# CITY OF ALBUQUERQUE

August 18, 2022

**Re: 1010 Pipe and Casing  
5609 Alameda Pl. NE  
Traffic Circulation Layout  
Architect's Stamp 05-22-22 (C18-D015)**

1 Site Plan

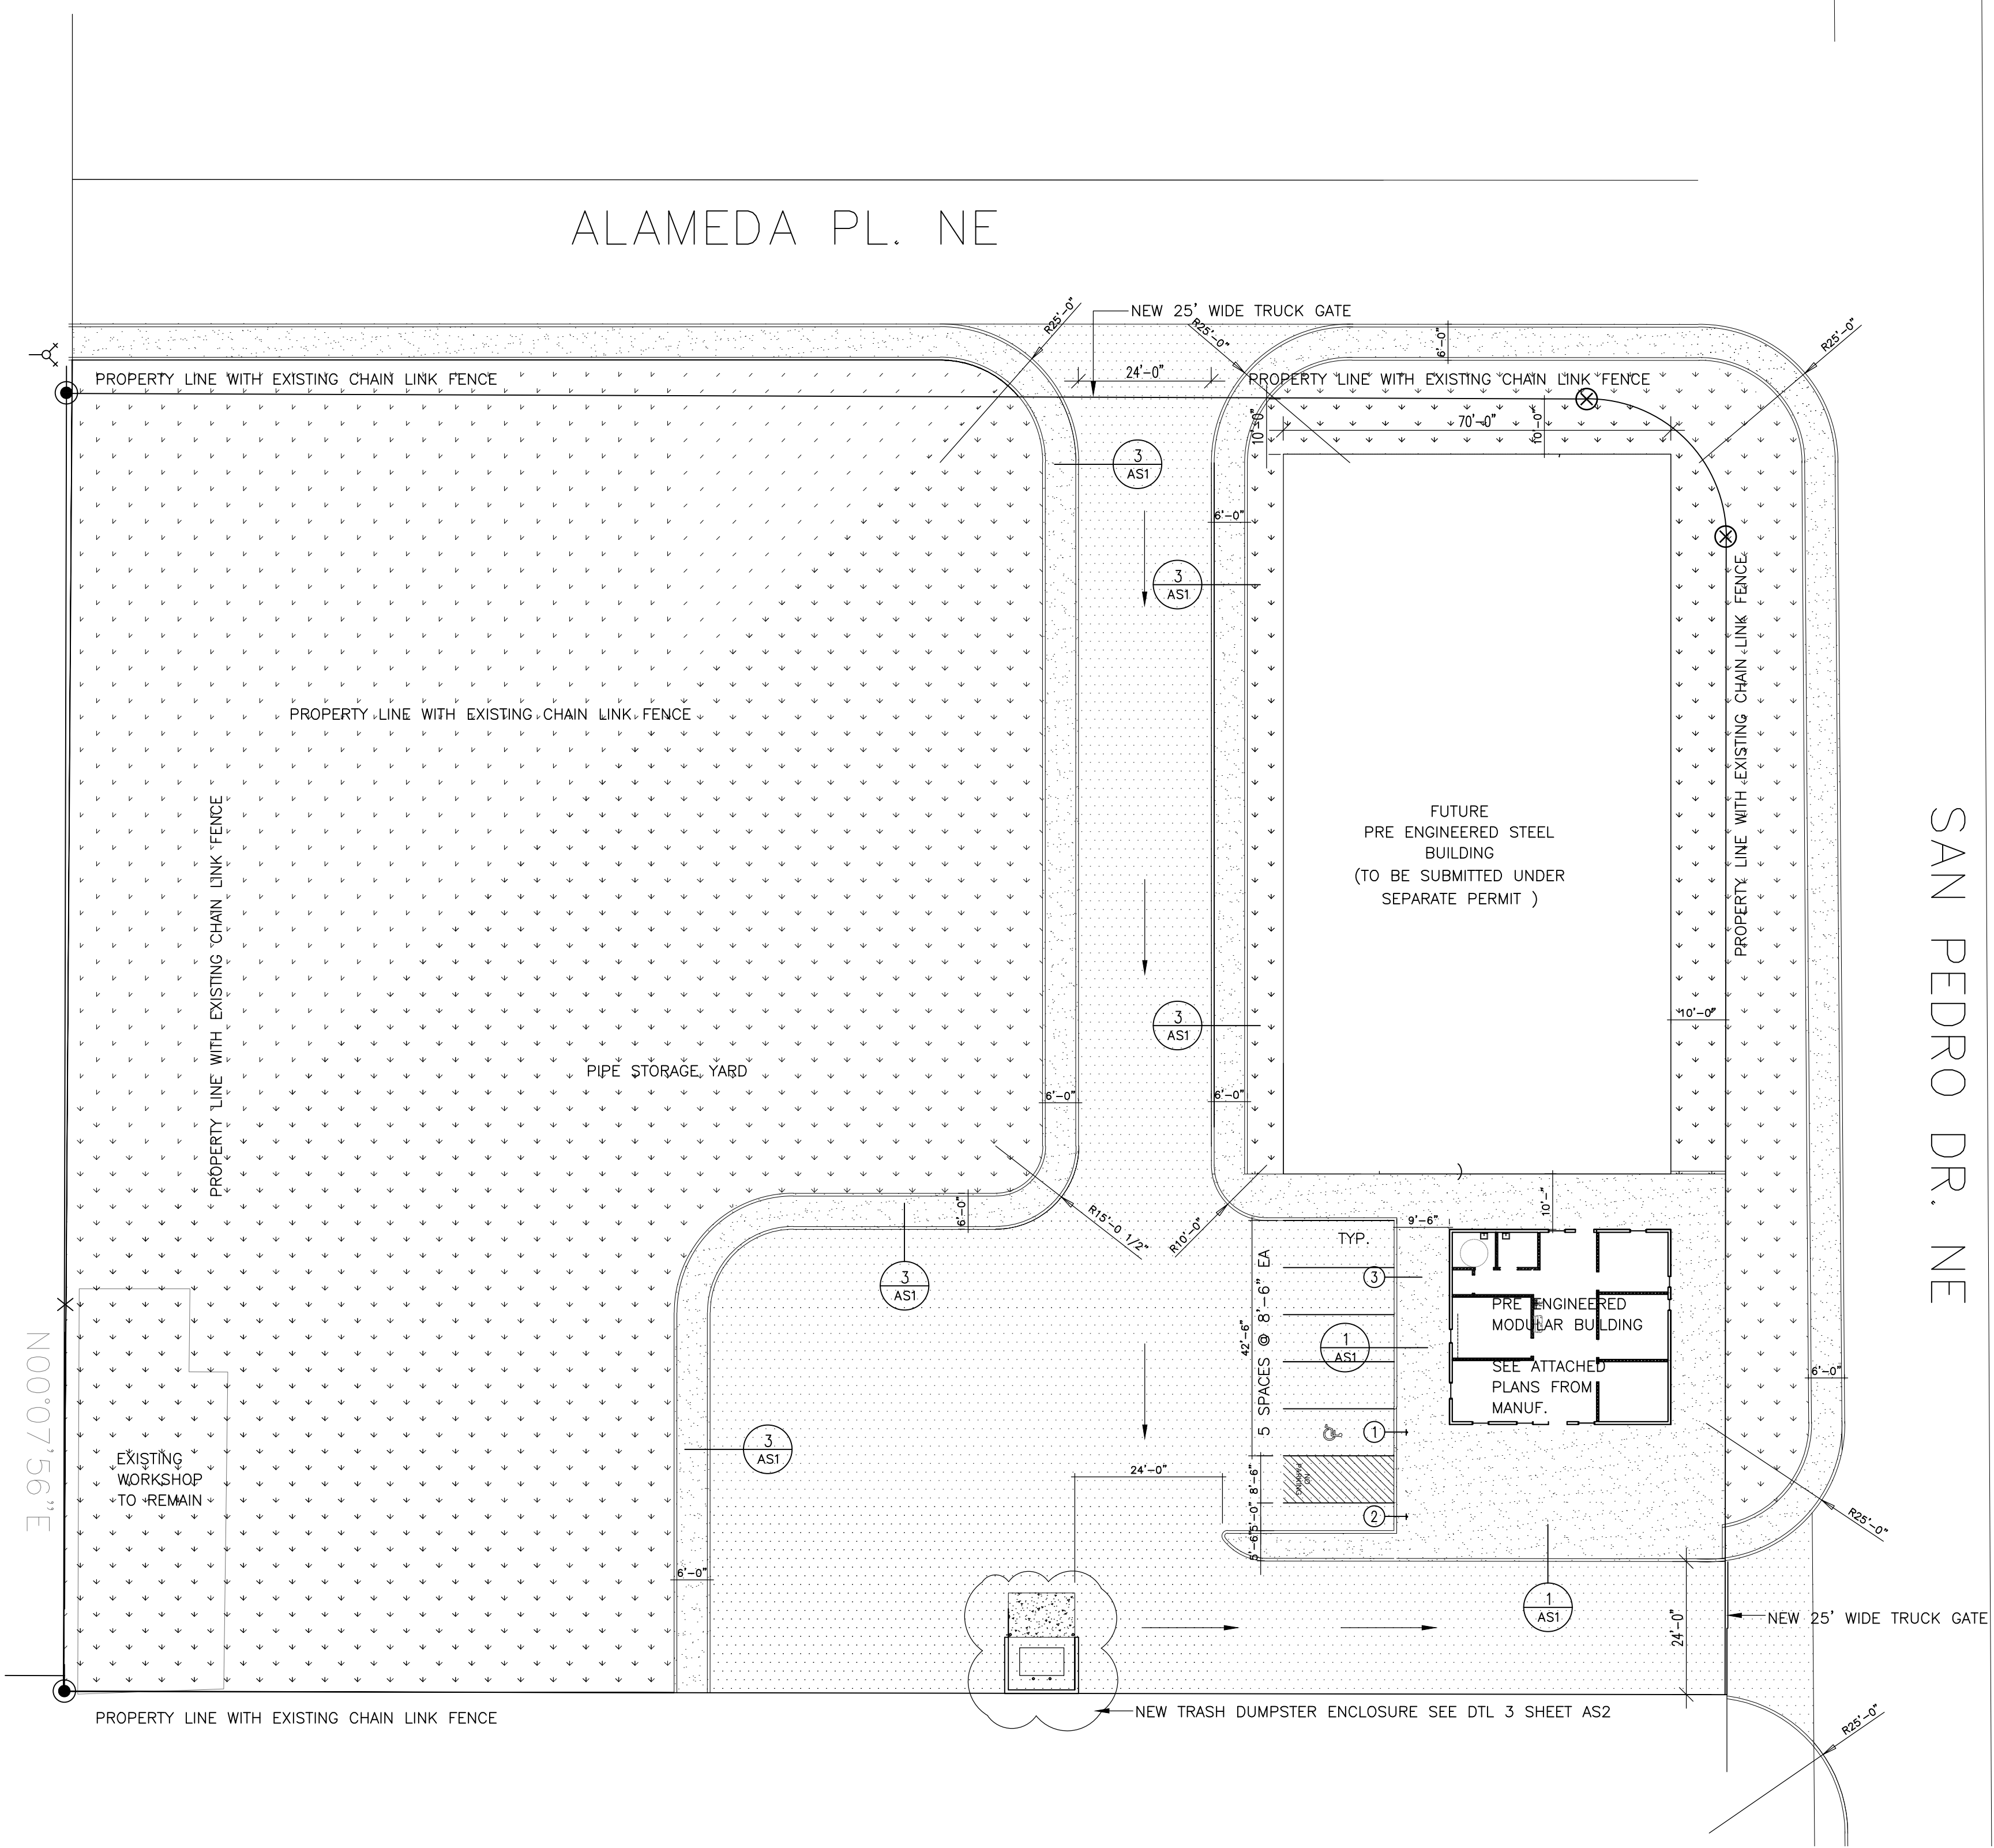
1. Please show a vicinity map showing the location of the development in relation to streets and well known landmarks.
2. Please show on site plan the North arrow.
3. List the number of parking spaces required by the IDO as well as the proposed number of parking spaces including bicycle and motorcycle parking.
4. Identify the right of way width, medians, curb cuts, and street widths on San Pedro Dr. and Alameda Pl NE.
5. Alameda frontage and San Pedro frontage: Sidewalk need to be built per COA std dwg 2430 and Curb and Gutter per COA std 2415 from property line to property line. For sidewalk waiver please contact Ernest Armijo [earmijo@cabq.gov](mailto:earmijo@cabq.gov). (505)-924-3991
6. Please list the width and length for all existing and proposed parking spaces. Some dimensions are not shown.
7. The minimum parking stall dimensions are:

8. The ADA accessible parking sign must have the required language per 66-7-352.4C NMSA 1978 **"Violators Are Subject to a Fine and/or Towing."** Please call out detail and location of signs.
9. Motorcycle parking spaces shall be designated by its own conspicuously posted upright sign, either free-standing or wall mounted per the zoning code.

14. List radii for all curves shown; for passenger vehicles. Radius for delivery trucks, fire trucks, etc. is 25 ft. or larger.
15. Per the IDO, a 6 ft. wide ADA accessible pedestrian pathway is required from the public sidewalk to the building entrances. Please clearly show this pathway and provide details.

16. Per DPM, a 6 ft. wide ADA accessible pedestrian pathway is required from the ADA parking stall access aisles to the building entrances. Please clearly show this pathway and provide details.

17. ADA accessible pedestrian pathway should not be placed behind parking space or adjacent to a vehicular way. Vehicle and pedestrian/wheel chair conflicts should be avoided as much as possible.

18. Refuse vehicle maneuvering shall be contained on-site. The refuse vehicle shall not back into the public right of way. provide a copy of refuse approval.

19. Provide a copy of Fire Marshal approval.
20. It is not apparent what type of pavement surface is being proposed. A hard driving surface will be required as part of this proposed project for parking area and drive aisles.

21. All one-way drives shall have "One Way" and "Do Not Enter" signage and pavement markings. Please show detail and location of posted signs and striping.

22. Please provide all proposed face signs details.
23. Please provide a sight distance exhibit
24. Show the clear sight triangle and add the following note to the plan: "Landscaping and signage will not interfere with clear sight requirements. Therefore, signs, walls, trees, and shrubbery between 3 and 8 feet tall (as measured from the gutter pan) will not be acceptable in the clear sight triangle.
